Dean Moor Solar Farm

Cultural Heritage Technical Note

August 2025
Prepared by: Stantec
PINS Ref: EN010155
Document Ref: D2.33
Revision: 1

- LEGEND**
- Order Limits
 - EXISTING FEATURES**
 - Existing Woodland/Scrub (Broadleaved)
 - Existing Woodland (Coniferous)
 - Existing Woodland (Out of Order Limits)

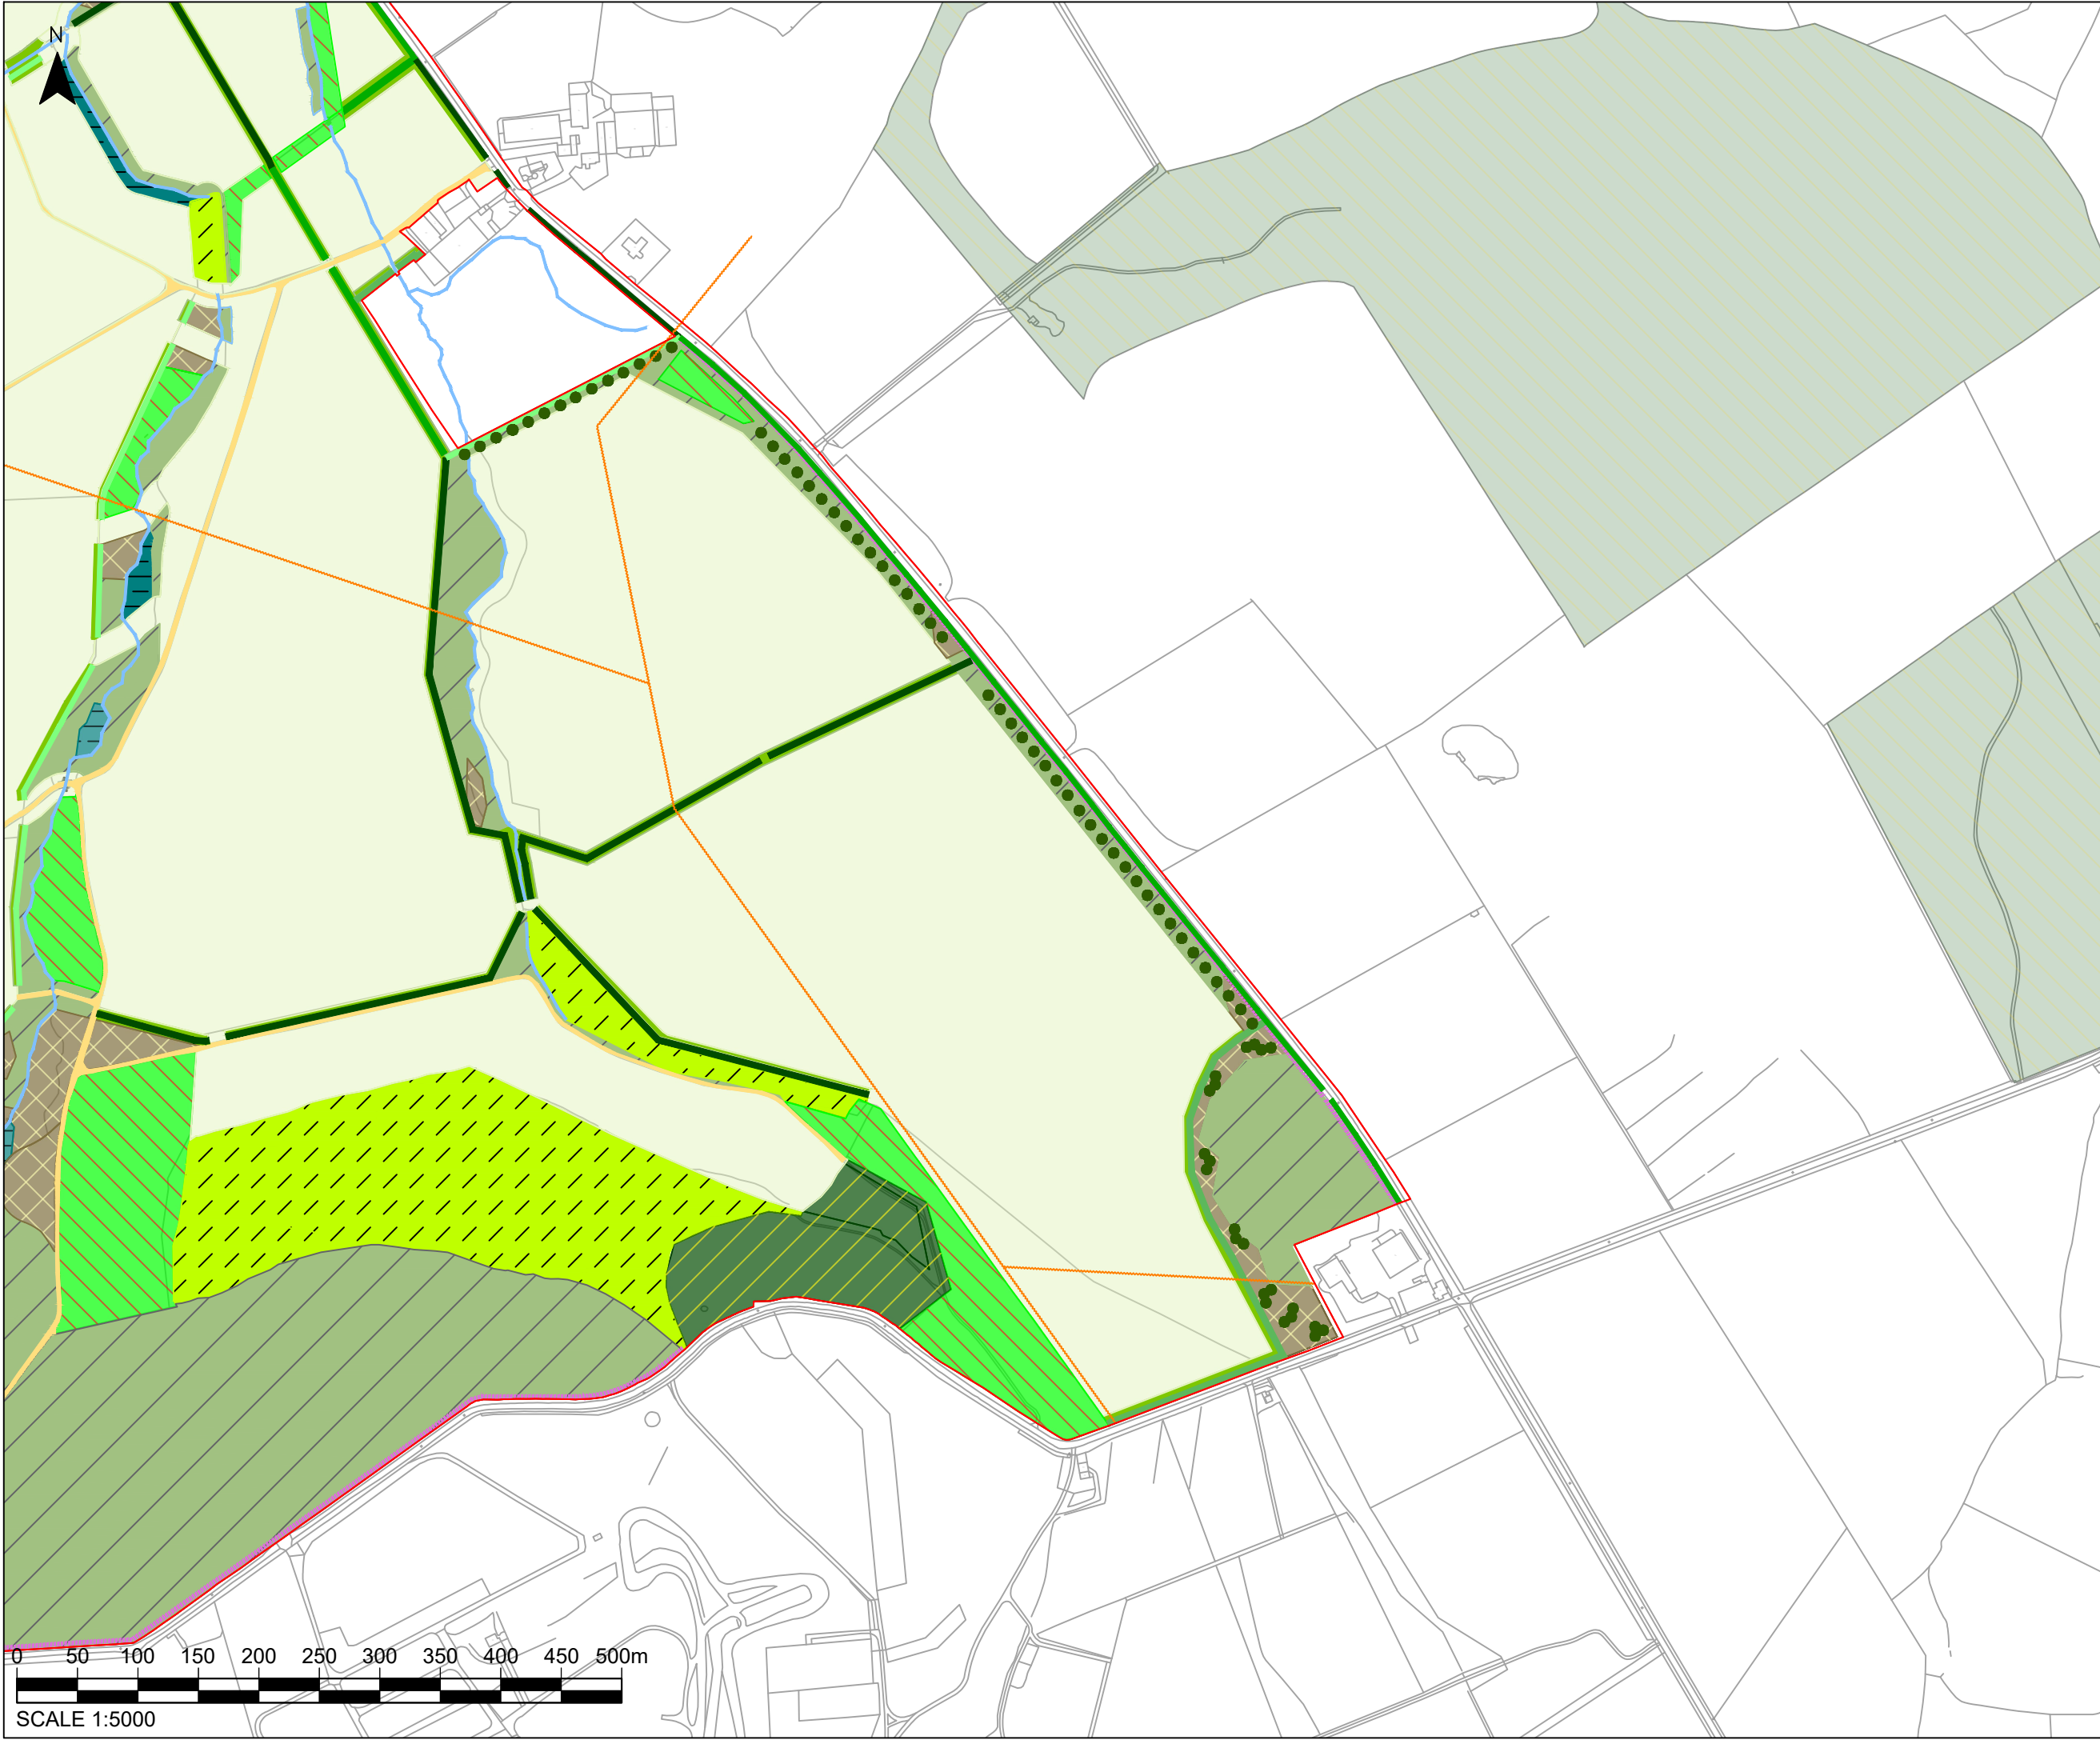
- 1.1.3 *‘Table 2.1 Grade II listed buildings and Grade II Registered Parks and Gardens should be placed in the ‘High’ category and not the ‘Medium’ category. Para 2.2.8 makes reference to the use of Design Manual for Roads and Bridges LA 106 as it ‘provides a useful framework for cultural heritage assessment’. As such, the criteria contained within Design Manual for Roads and Bridges LA104 would have been more appropriate – which assigns a ‘High’ value to receptors of ‘national scale’. Grade II listed buildings are designated to their architectural or historic interest on a national scale (as are Grade II Registered Parks and Gardens).’*

- 2.2.3 The receptor is situated approximately 150m from the Site boundary. The farmhouse has extensive views across the adjoining landscape, due to the surrounding topography; with the farmhouse situated on a slope which falls away towards Dean Moor. The views from the rear of the property looking across the Site will be affected by the Proposed Development. Whilst the panels comprise low level infrastructure, they will foreshorten long-distance views, resulting in a change to the characteristics of the receptor setting and eroding the rural open nature of the landscape

- 2.2.4 The landscape mitigation proposes a green infrastructure buffer, which has been included within the Works Plans [APP-007] and is reinforced by proposals in the Landscape Strategy Plan (LSP) (ES Figure 7.6.1 – 7.6.5) [APP-088]. This buffer surrounds the part of the Site in closest proximity to the receptors with proposals to include new landscape structural elements (trees/scrub) to help screen the most direct near-distance views.

- 2.2.5 The LSP also includes reinforcement of existing hedgerow field boundaries across Areas A and B, which are expected to also help break up views and prevent a ‘block’ appearance. As per the Design Parameters Document (DPD) [APP-049] the Solar PV infrastructure (Work No. 1) will have vegetated ‘aisles’ between rows of solar panels which to avoid the appearance of a continuous façade, especially when viewed from a partial or full side elevation of the arrays which will be oriented with panel facades facing south, as is the case from this receptor to the west/north-west.

- 2.2.6 These measures ensure that the visual impact from the closest panels (located at approximately 150m from the receptor) is reduced. In summary, it is considered the proposed landscape mitigation would minimise the impacts caused by the Proposed Development.
